CITY OF ALBUQUERQUE

August 31, 2023

**Re: University View Apartments
Lot 001 Block 8 Volcano Cliffs
Traffic Circulation Layout**
Architect's Stamp 08-11-23 (C09-D016B)

SITE PLAN

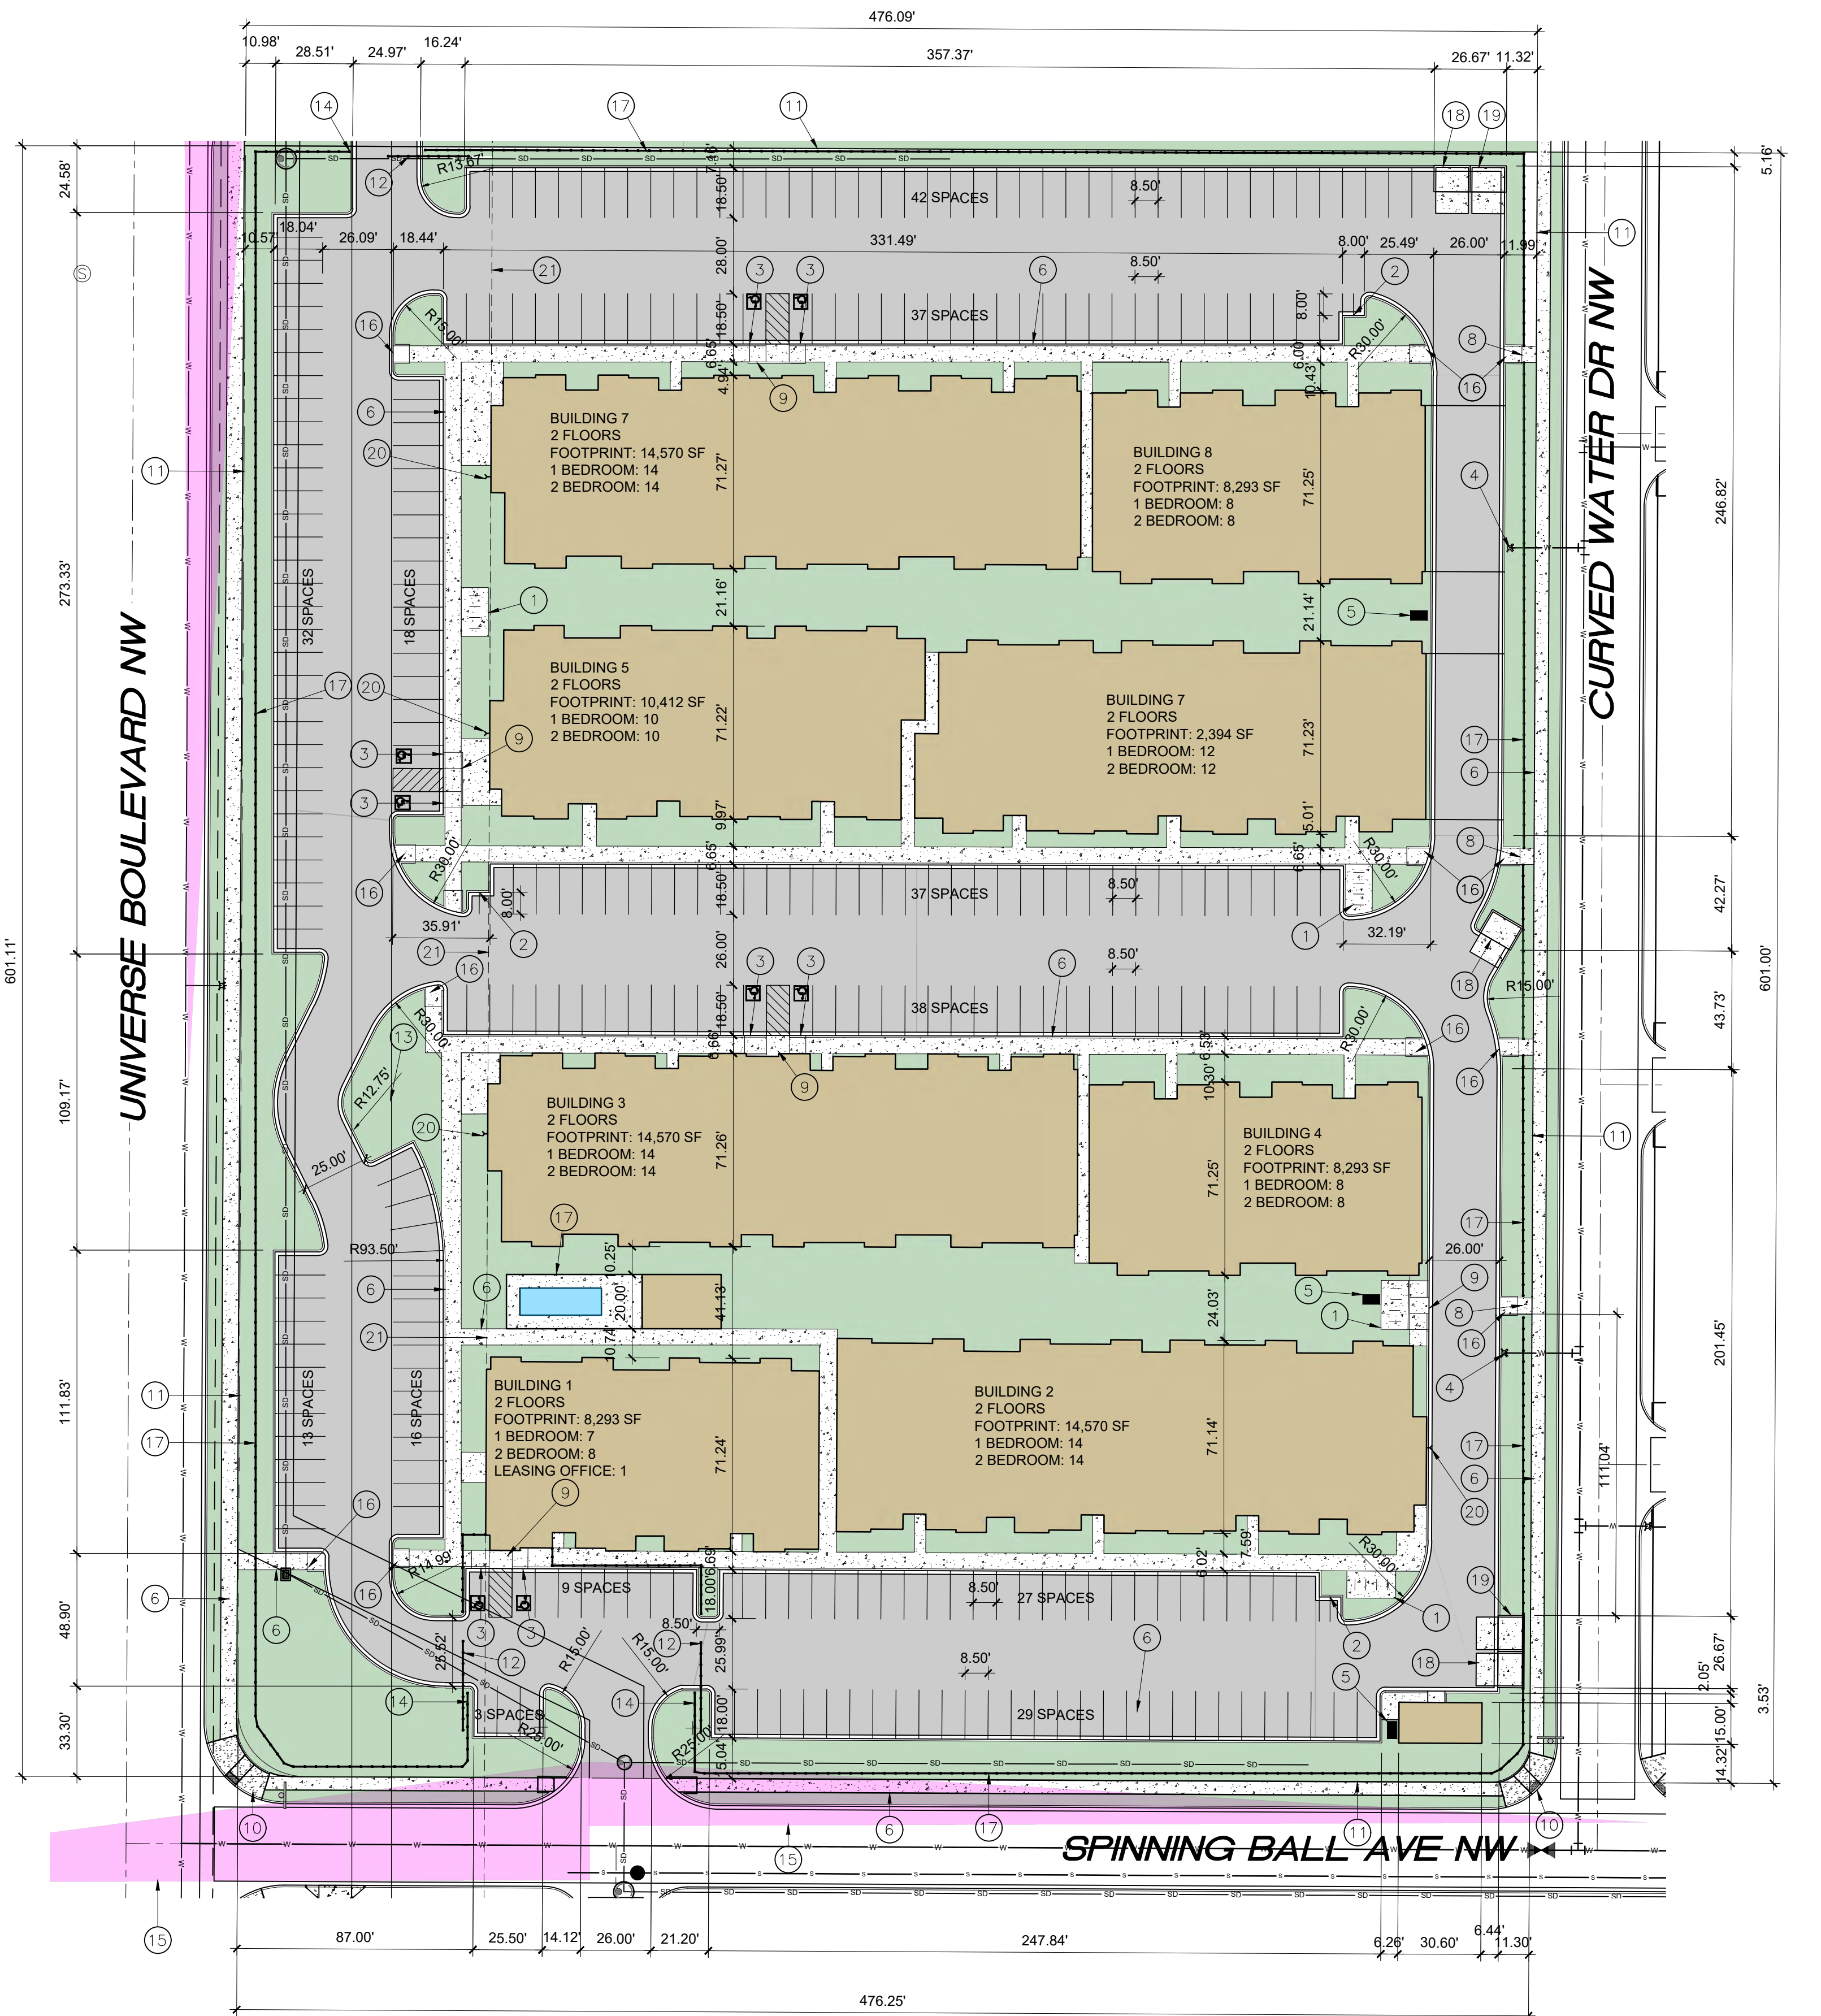
1. Identify all existing access easements and rights of way width dimensions.
2. Identify the right of way width, medians, curb cuts, and street widths on Universe Blvd, Spinning Ball Ave, and Curved Water Dr.
3. Provide site access design details, or reference COA std dwg.
4. Please provide Infrastructure list.
5. Please show on the site plan the City right of way improvement that required by Engineer Matt Grush.
6. Please provide approved plat or shared access agreement with the northside property.
7. Provide a copy of Fire Marshal and Solid Waste approval.
8. The pavement marking "MC" should be shown in the opposite direction for motorcycles entering the parking space.
9. Please provide Legend on the site plan.
10. Please provide a letter of response for all comments given.
